**Re: NOBIS Rehabilitation Hospital at 1100 Woodward PI NE
Erosion and Sediment Control Plan (CPN 703383)
Engineer's Stamp Date 1/29/26 – J15E053 (SWQ-2026-00007)**

Based on the information in your submission received on 2/03/26, the ESC Plan cannot be approved until the following comments are addressed.

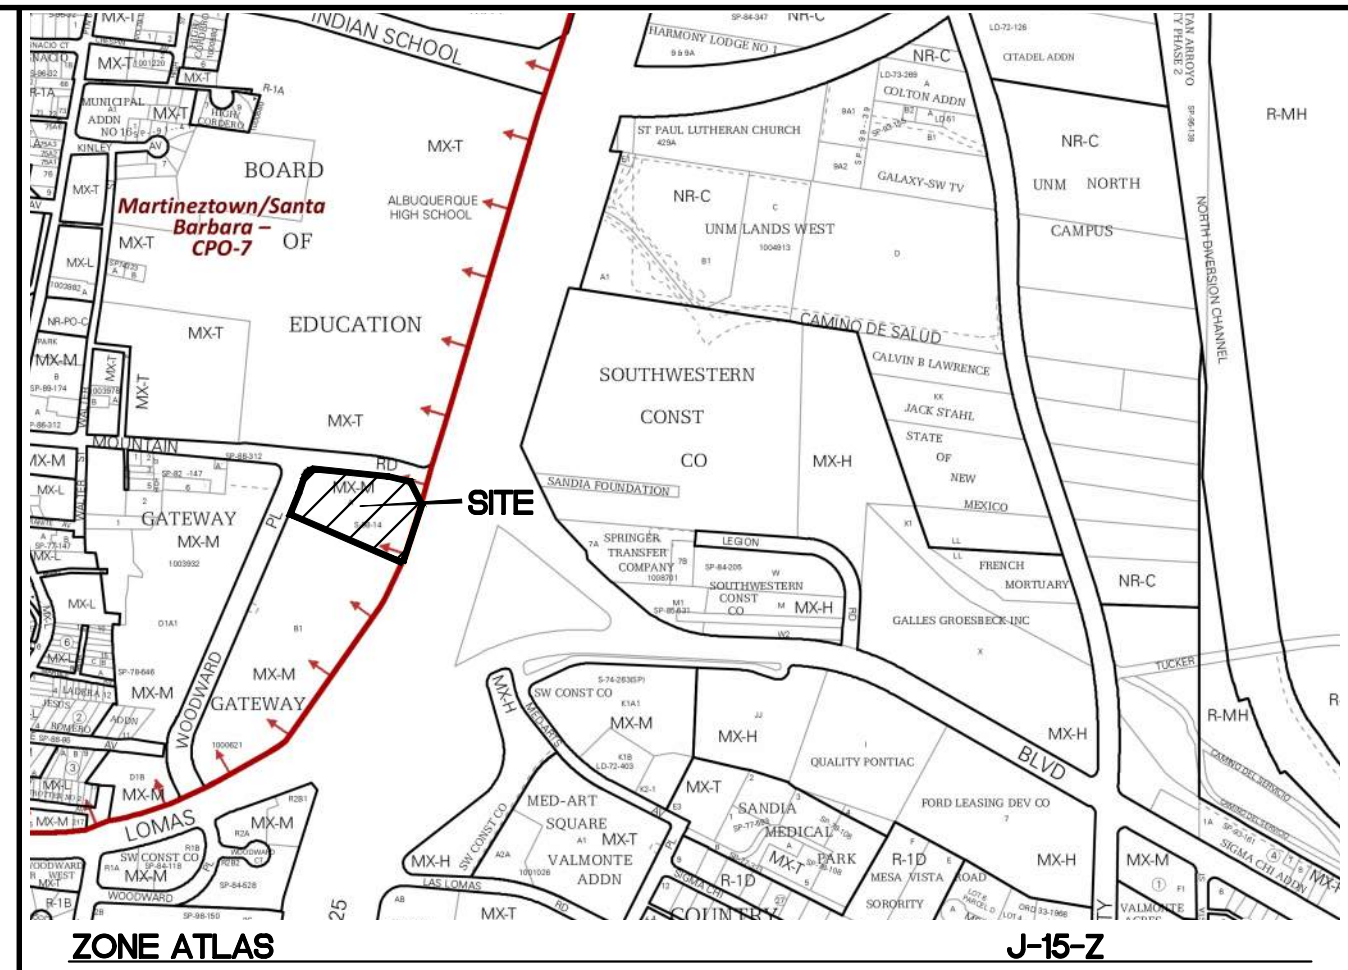
4. The silt fence on the ESC plan may be required by the City of Albuquerque Environmental Health Department, but it cannot be used as stormwater quality control along a sloping perimeter. Temporary Diversion Channels (DC) are well-suited for these sloping perimeters to transport construction stormwater to temporary Sediment Basins and Sediment Traps (SB & ST). Cut-back-curb (CBC) may be used instead of the DC. Temporary rock stabilization will likely be necessary with either type of ditch. Please add appropriate controls to the ESC Plan, including design calculations and construction specifications as required by Parts 2.1, 2.2, and 9.6.1.c.i of the CGP, where it states "The SWPPP must identify and document the rationale for selecting these BMPs and/or other controls. The SWPPP must also describe design specifications, construction specifications, maintenance schedules (including a long-term maintenance plan), criteria for inspections, and expected performance and longevity of these BMPs."

5. Calculations and construction specifications are missing for the SBs, and controls for directing construction stormwater into the SBs are inadequate. These controls must be the first items of construction per CGP 2.1.2 and 2.1.3, and they must remain in effective operating condition during permit coverage as per CGP 2.1.4. The DCs should be placed

at the downgradient edge of the site, and the SB should be positioned at the lowest corner for maximum efficiency throughout construction.

7. How will drainage from the private parking lot on the neighbor’s property to the south be prevented from entering this site? Provide details, both temporary and permanent, of the paved roadway connection shown in the southwest corner of this site that ensures drainage from the neighbor’s property will not flow into this site.

8. The SWPPP must include site-specific interim and permanent stabilization per CGP 9.6.1.c.i. Specify a “Landscape Buffer Swale” between the sidewalk and curb, per “COA DWG 2414” on both the Work Order for CPN 703383 and the ESC Plan.
